July 9, 2018

**Re: Falcon Marketplace Preliminary Plan (SP-17-001) Response 4 - Landscape**

LANDSCAPE PLAN - AREA 'A'

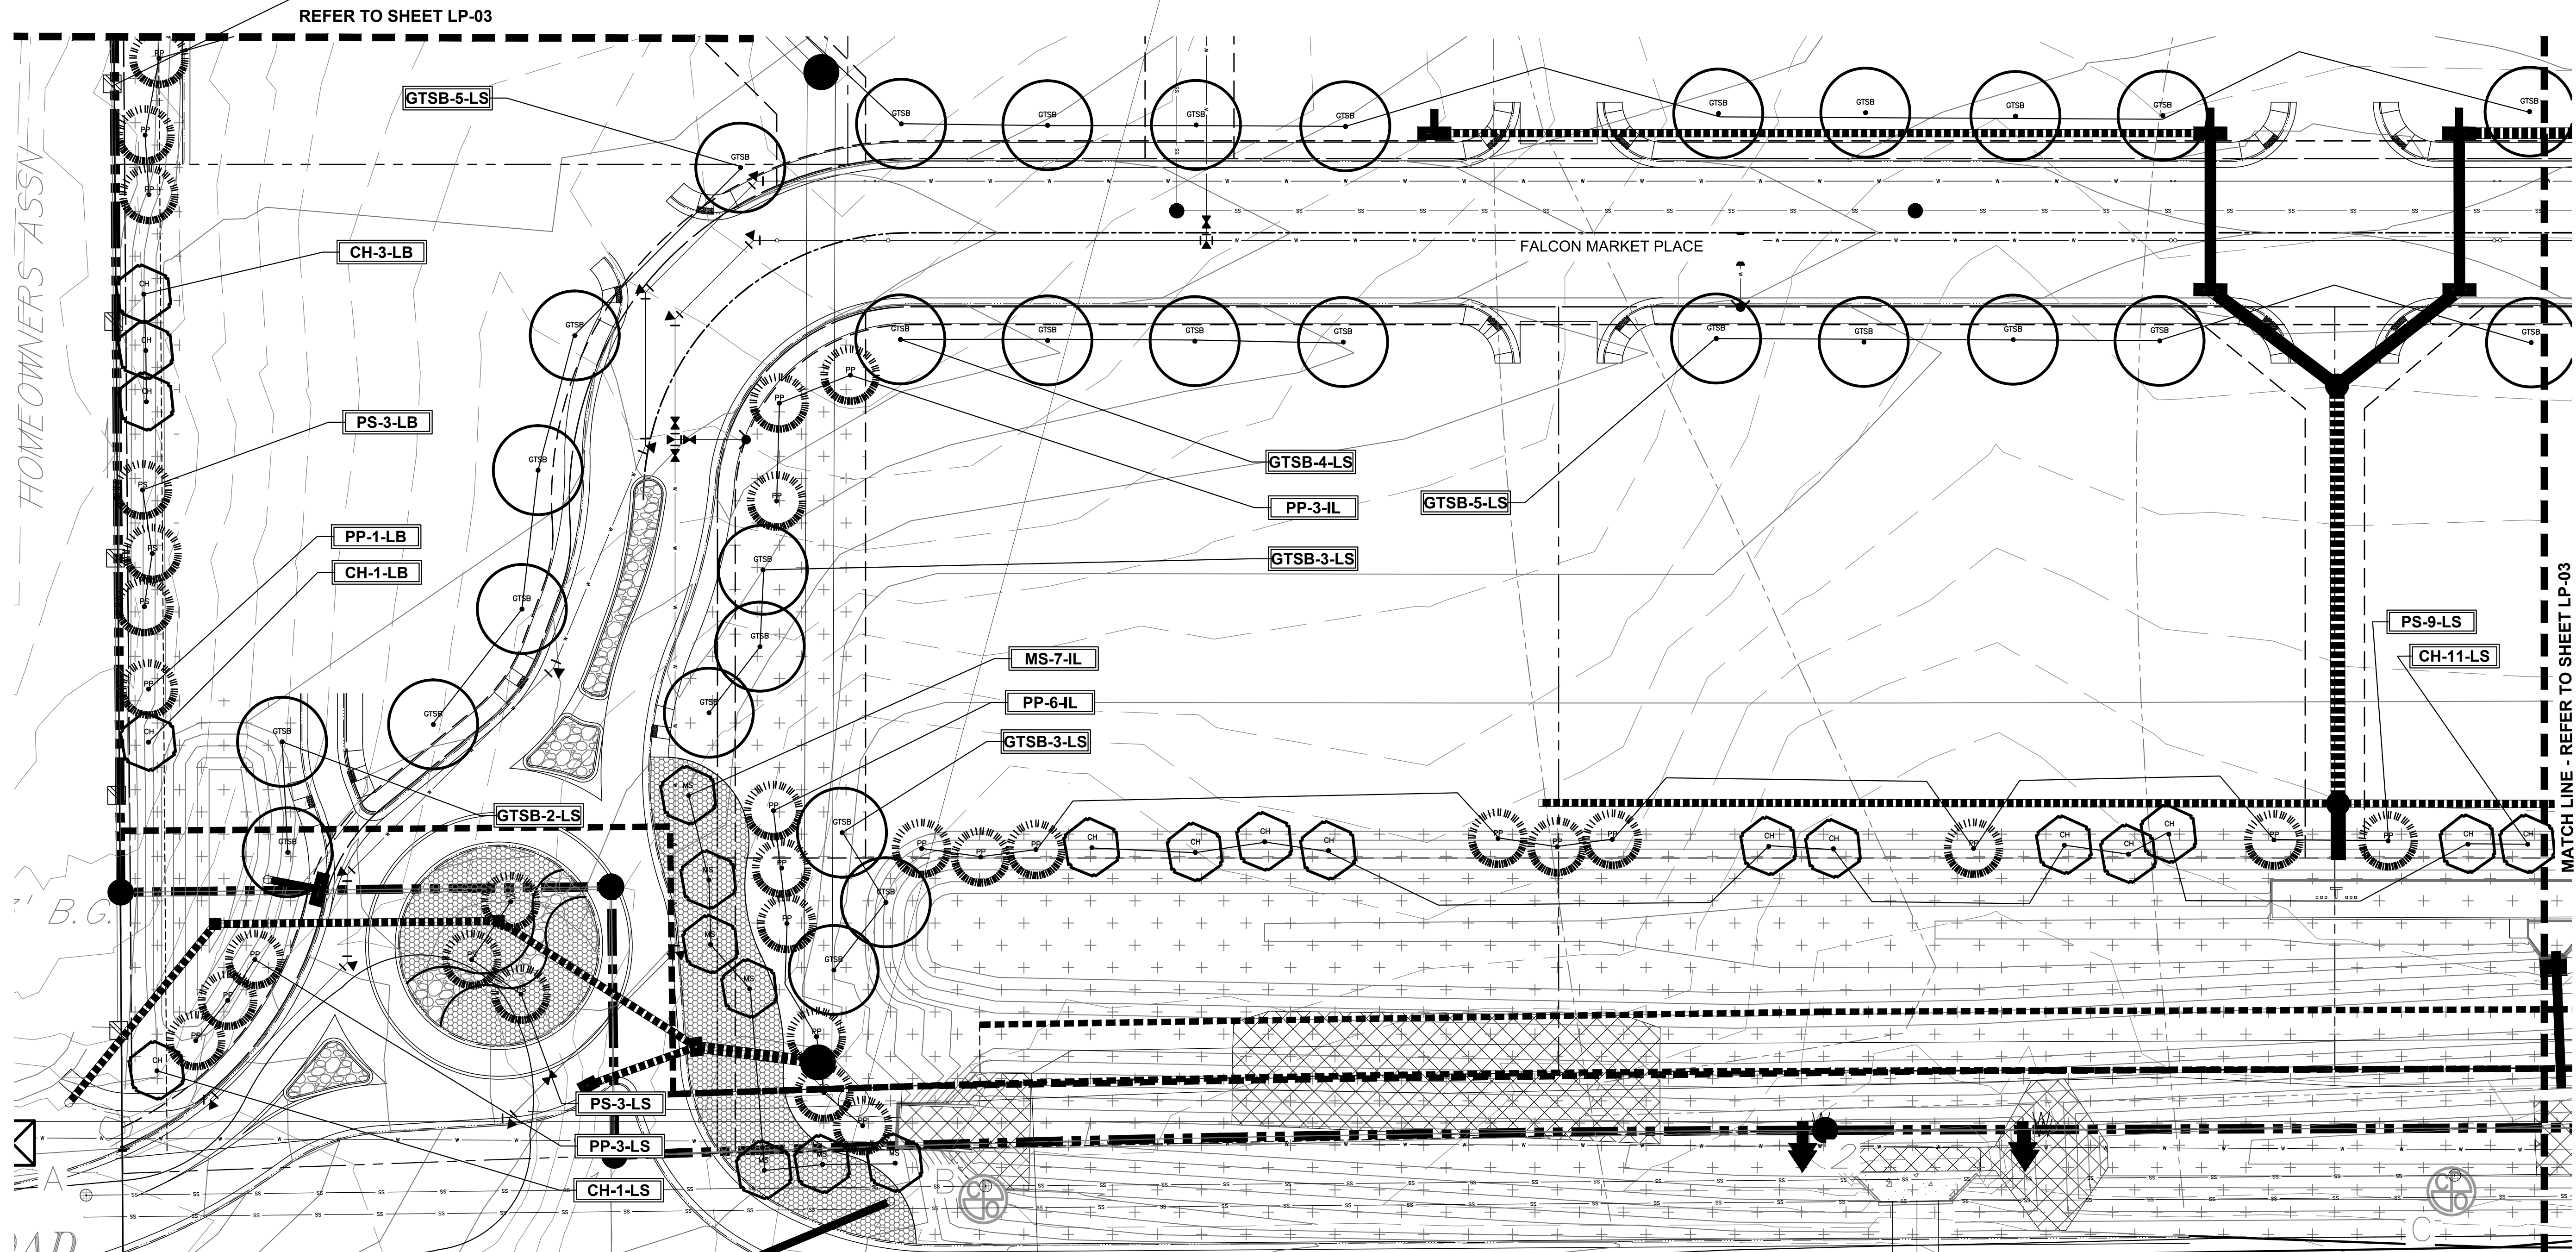
6. Please identify the tree/shrub species on the plan so that staff can verify numbers and site visibility. **Complete**
7. Provide a detail of the fence. A 7' fence is now allowed per Code on property lines. **Fence called out on plan along west boundary. Refer to details on site plan.**
